Your Ref: OWPC20810
Our Ref: EP/160/18/PL 02-11-2018
Please ask for:
Mr J Baeza

Variation of condition No.3 imposed under planning reference no: EP/45/17/HH relating to the proposed materials

11 Beechlands Close East Preston

Proposed Roof Tile – Marley Modern Tile, colour smooth grey.

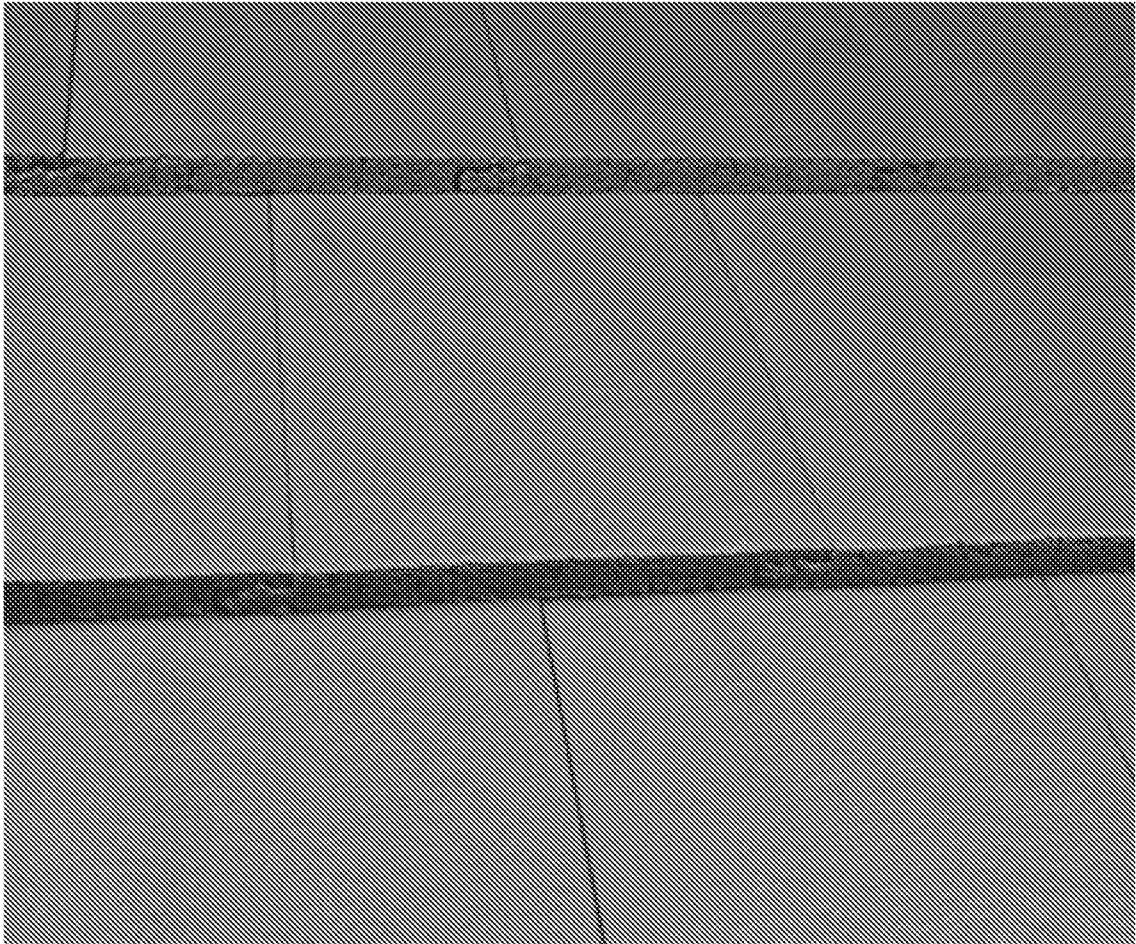
Attention needs to be given to the eastern side, the Vermont Way side of this large building, anyone living along this road, visiting this road or just passing through, cannot help but be overpowered by this large grey blob that looms over our bungalows.

The grey roof is totally out of place and is not acceptable.
